Subject: FW: Application Y/42/19/DOC Yapton Metal Company Burndell Road Yapton BN18 OHP

Further WSCC Highways comments

Site Plan (Proposed) 1:200

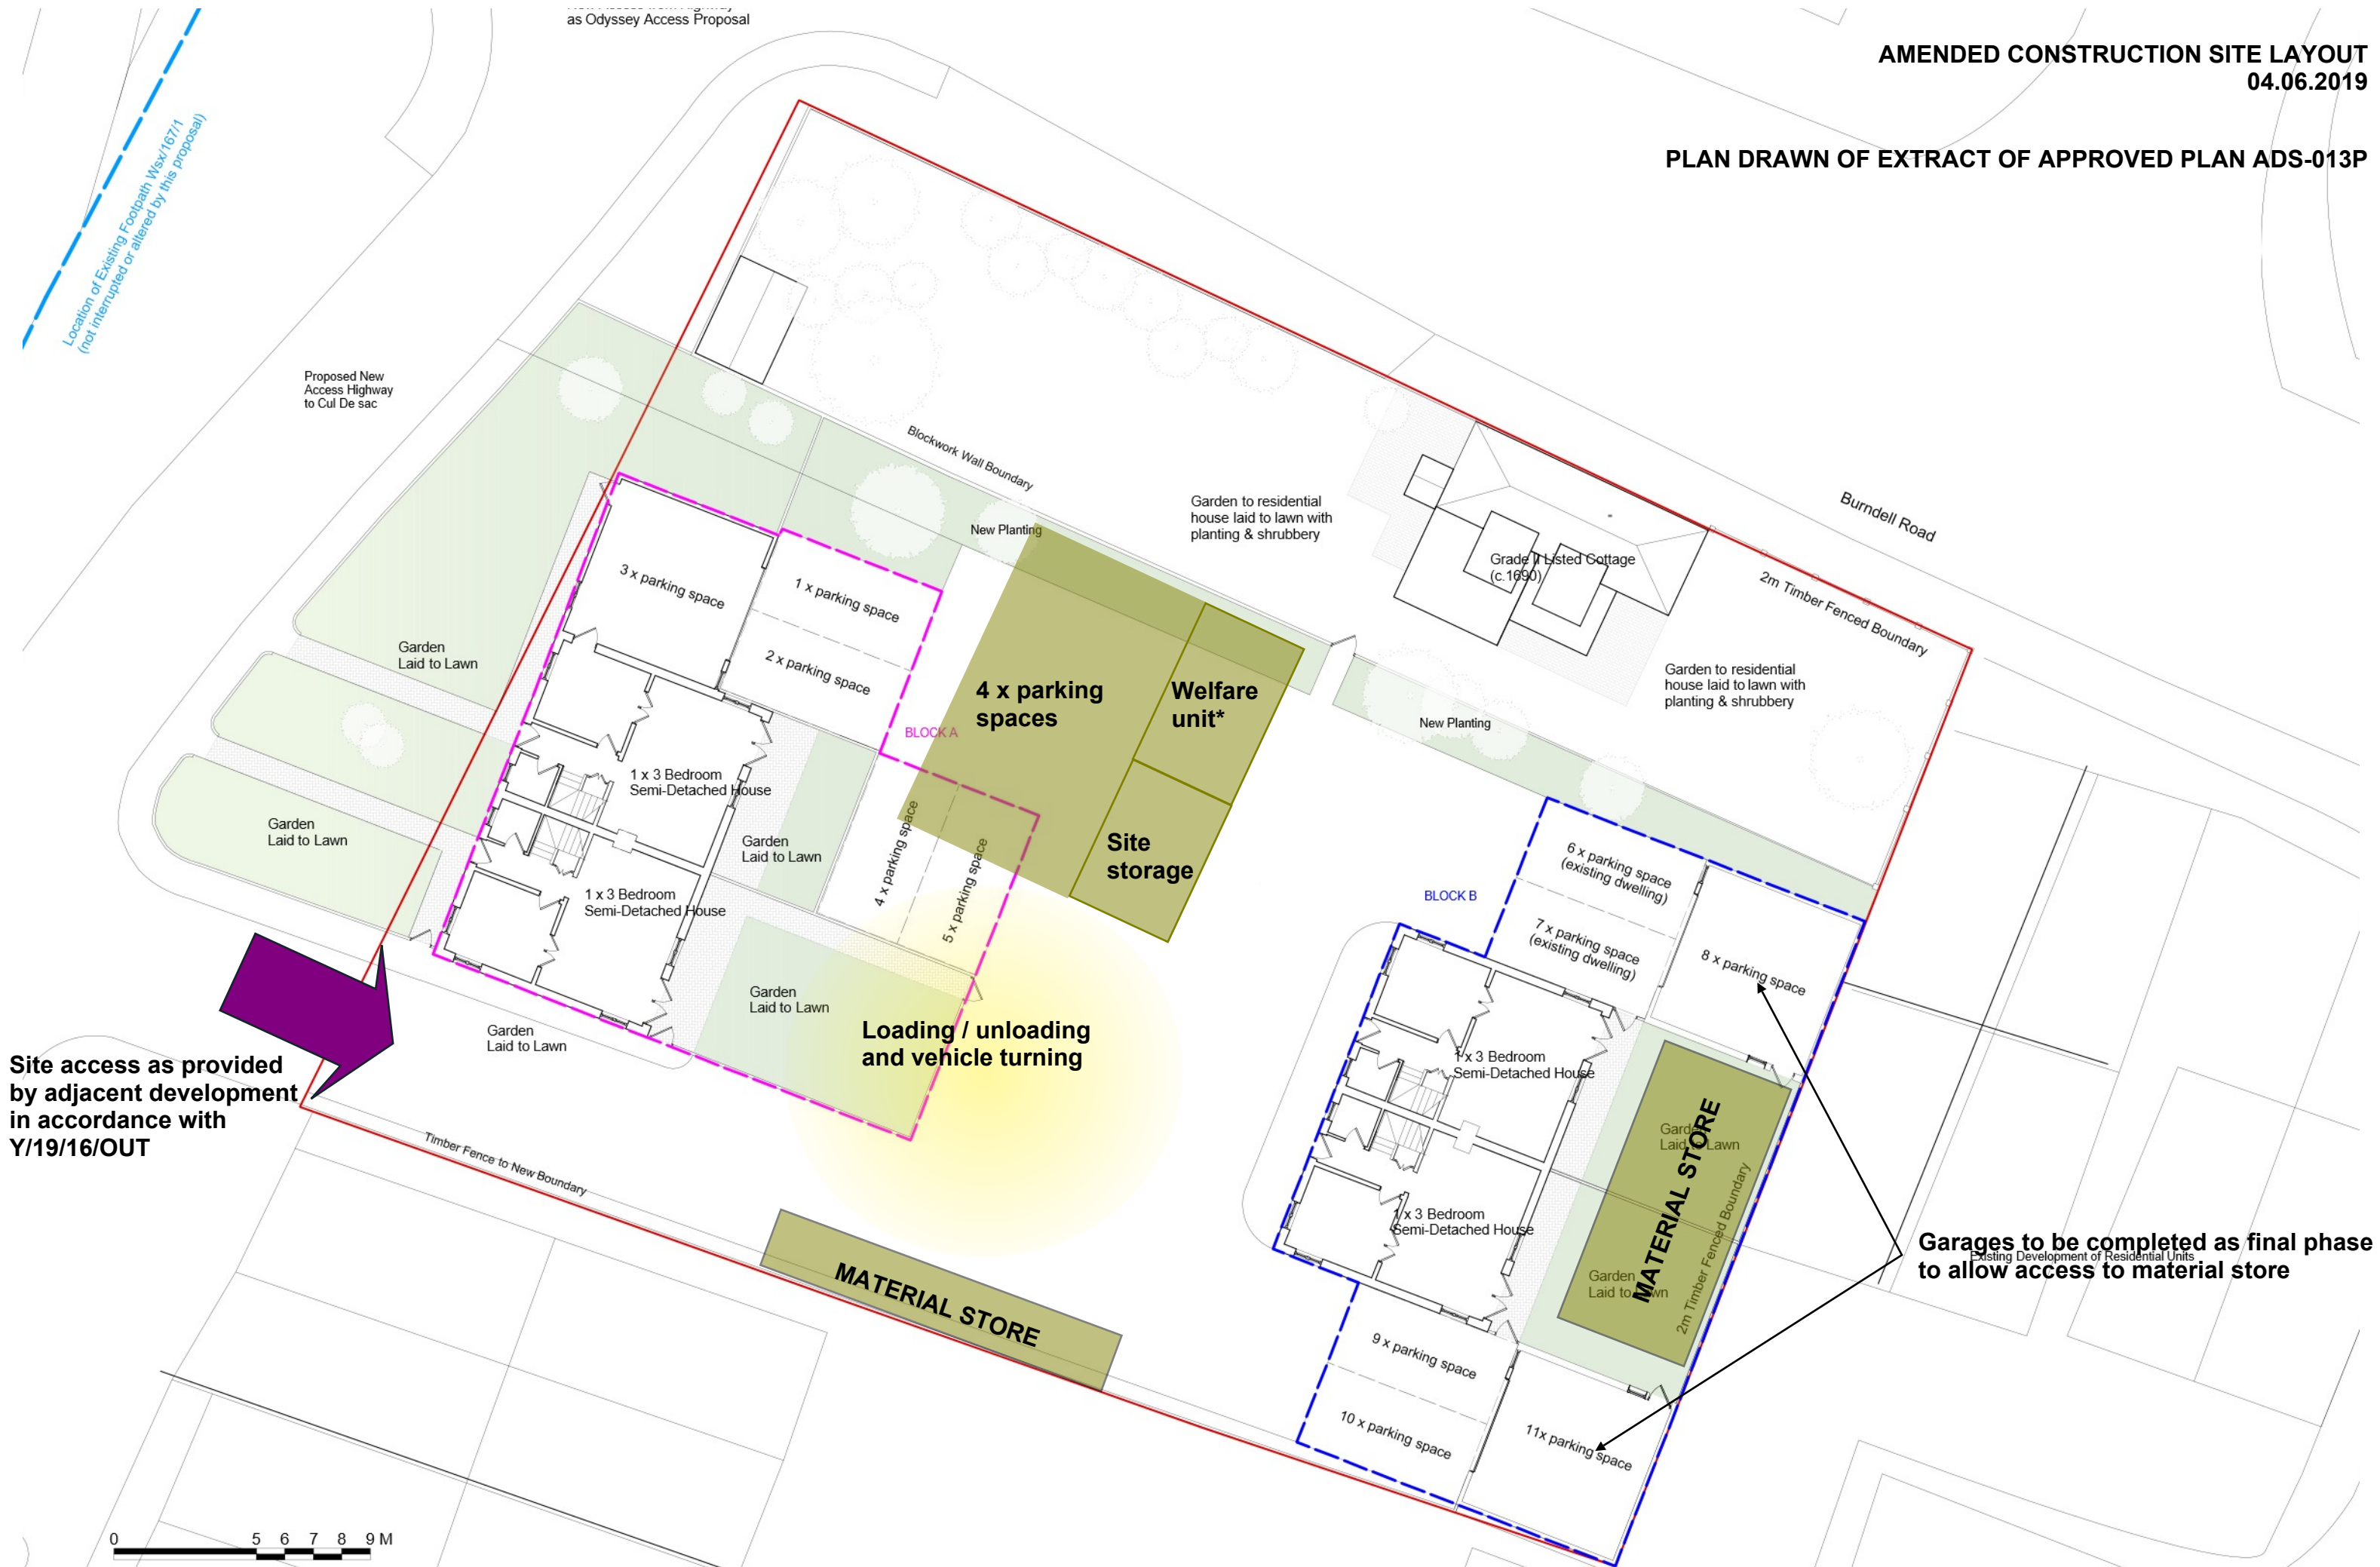
Swept path tracking for a refuse collection vehicle was demonstrated as part of the original application. Nevertheless, with the location of the material store and possibility that construction vehicles could be larger it is not clear whether such vehicles could turn on site during construction phase.

Whilst I am aware that the access as part of the adjacent development has been constructed and will be used to access the site, it is unclear whether sufficient length of road into the adjacent site (to the south) is available to allow construction vehicles to turn and thus not reverse to Burndell Road.

In summary I would seek some clarification from the developer on whether they intend to have construction vehicles turn within the site (and if so demonstrate this via swept path tracking) or clarify whether the current access road to adjacent site is currently available/ in a suitable condition to be used for this purpose. Ideally the site set up plan should show the extent of adjacent access road available and include swept path tracking of largest construction vehicle required.

They will need the information unless you wish to amend your plans to show access for construction vehicles from the permanent access? You are not going to be able to get a decision before the 6th June so it would make sense, to change the Site Set Up Plan, no?
